Address: 2 Taylor St

Permit # 2014-01440

CHECK-LIST AGAINST ZONING ORDINANCE

Proposed Use/Work - build 3 story style family - $20\frac{46}{12} \times 32\frac{32}{12} \times 12\frac{5}{12}$

A201

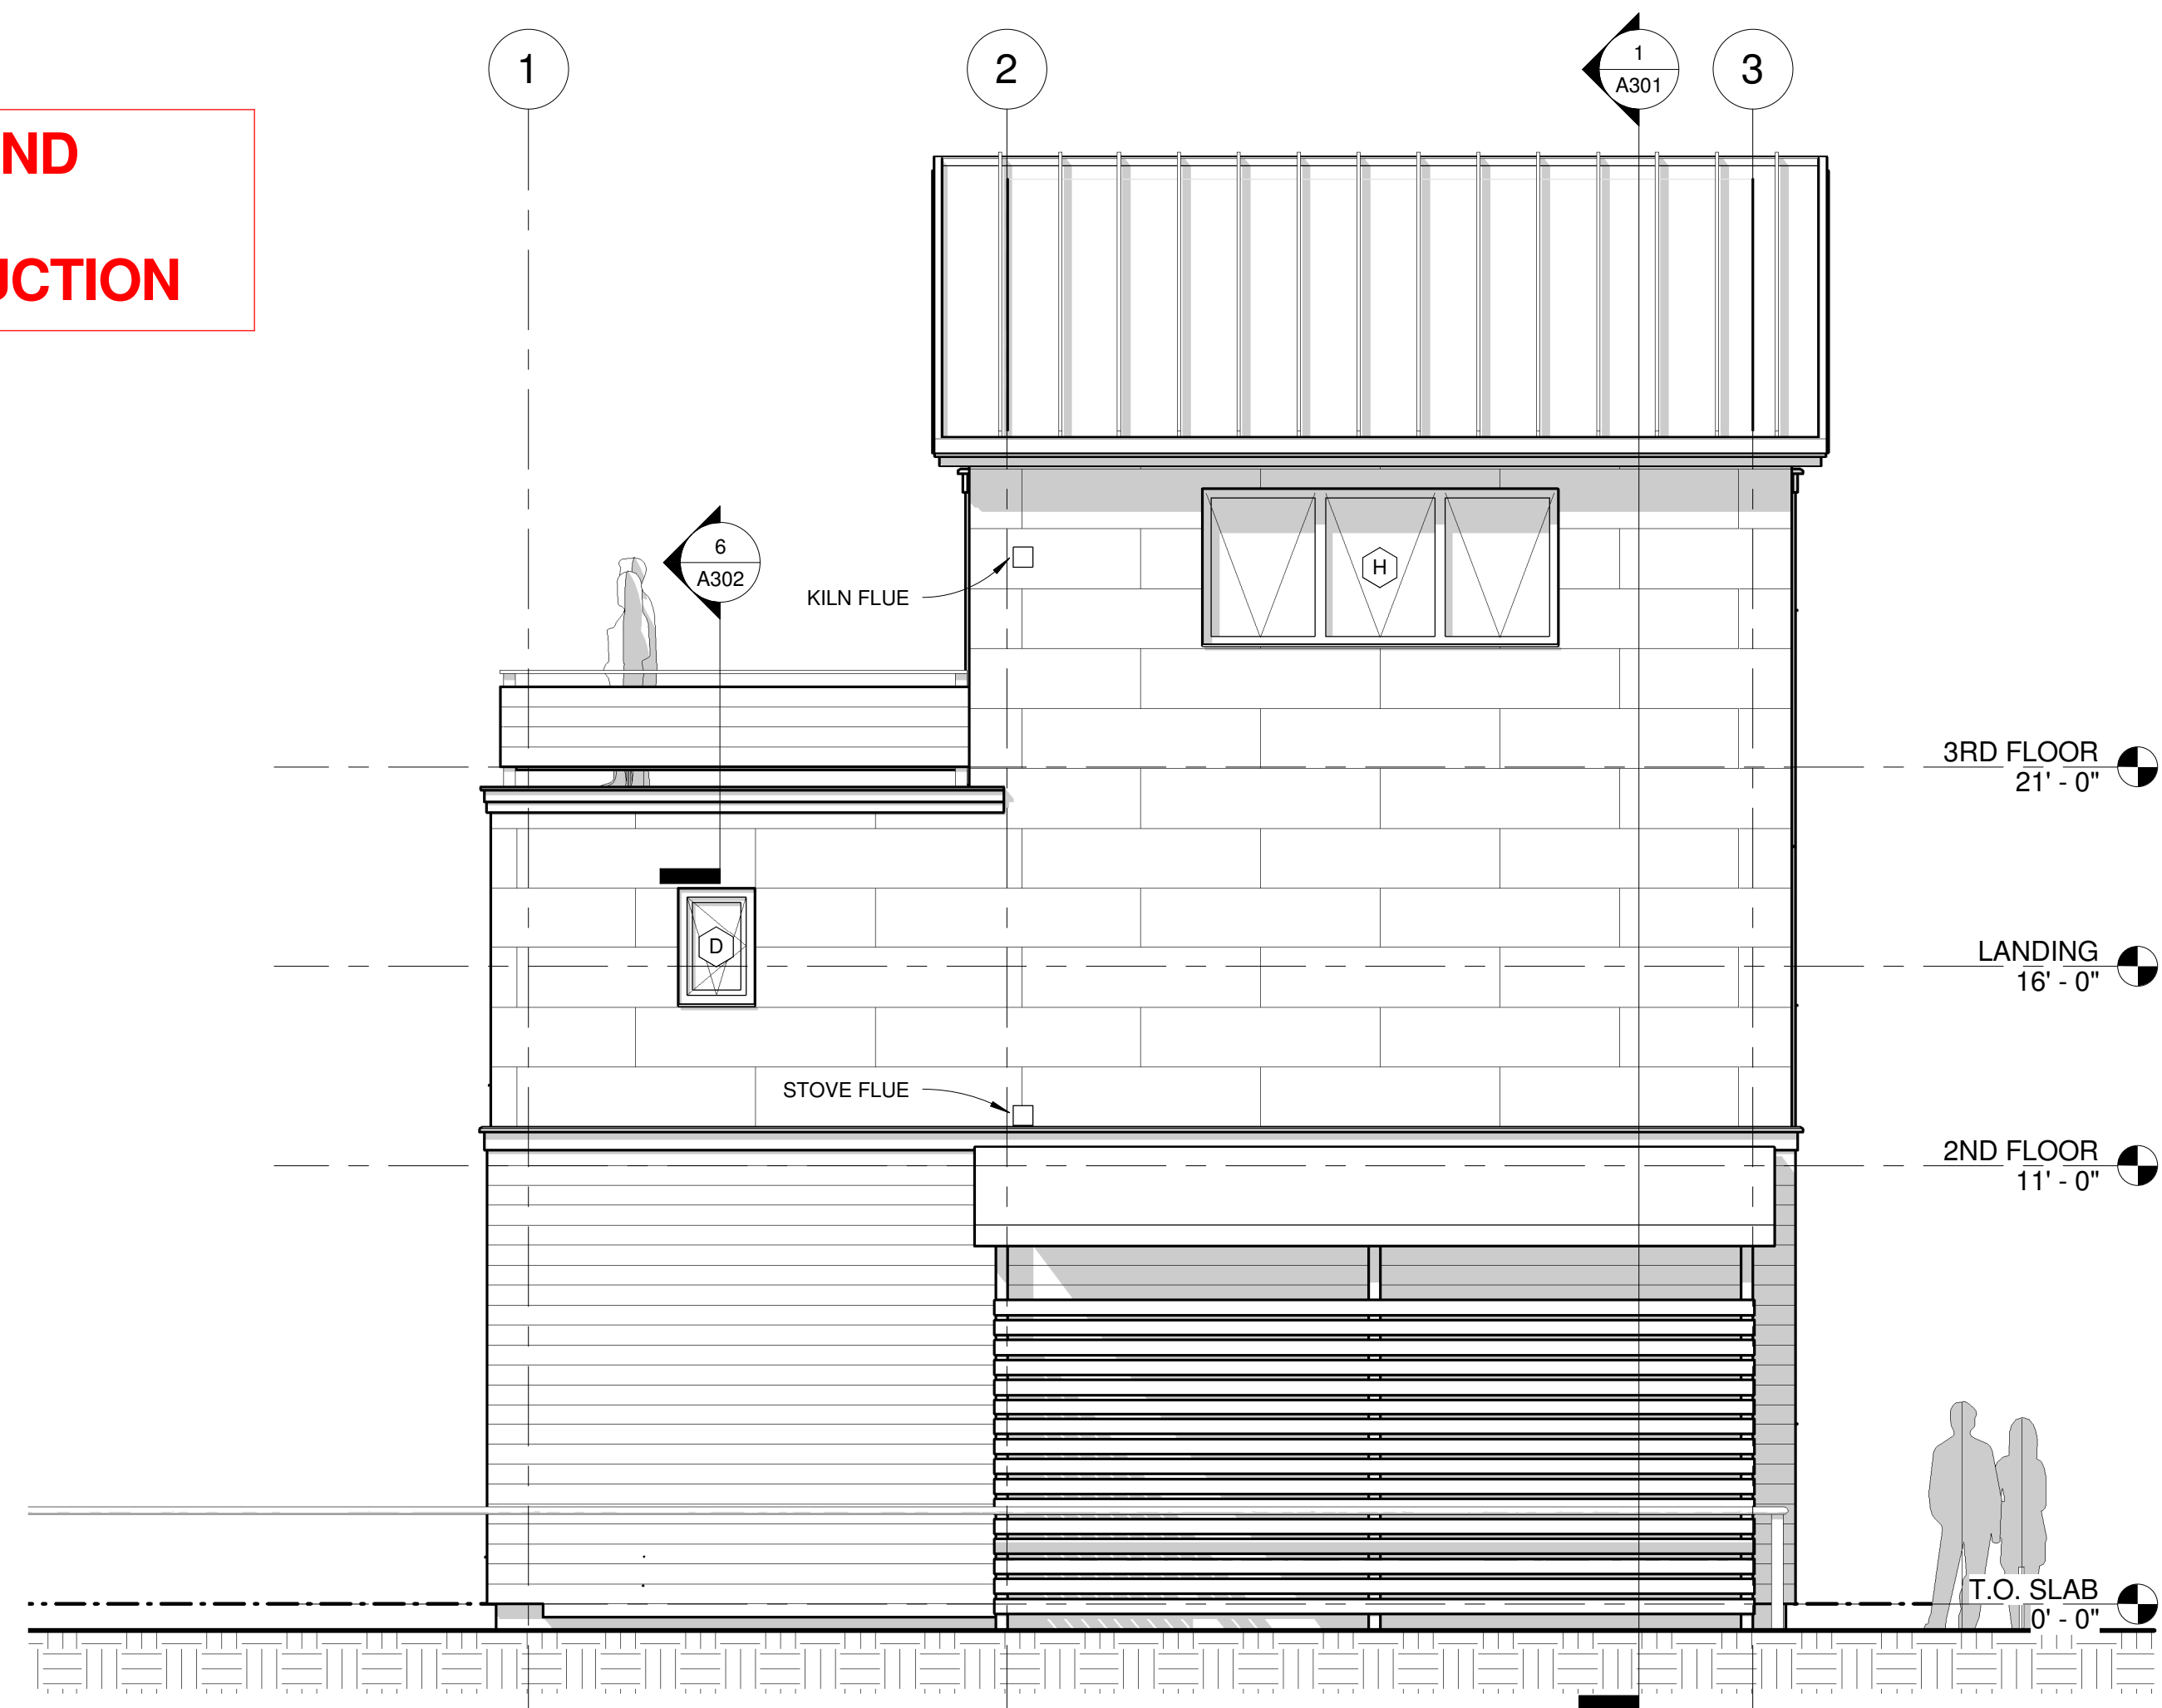
Rear Yard - min of 4' - ^{11.5 scaled OK} (10 may height) $30'6\frac{5}{8}" + (2 Taylor) 34'1\frac{3}{32} = 64.65' \div 5 = 12.93'$ between buildings ^{13'8 1/2" given (OK)}

Side Yard - ~~min 4'~~ (left side) - 15' min - $35.7'$ scaled OK b property line - needed 12.93' between buildings (OK)
sid - side street / May - 10' max - less than 10' (OK) - 1' from building (OK)

Projections - storage shed ~~8' x 16'~~ $7.23 \times 15'$ - 16' x 6.1"

Height - min - 2 stories above grade of street max 45' - midway scaled is 33.44'

$16' \times 6.1" = 97.28'$
- shed $13 \times 7.23 = 97.3\phi$
x must be 5' from property line
5.15' scaled (OK)
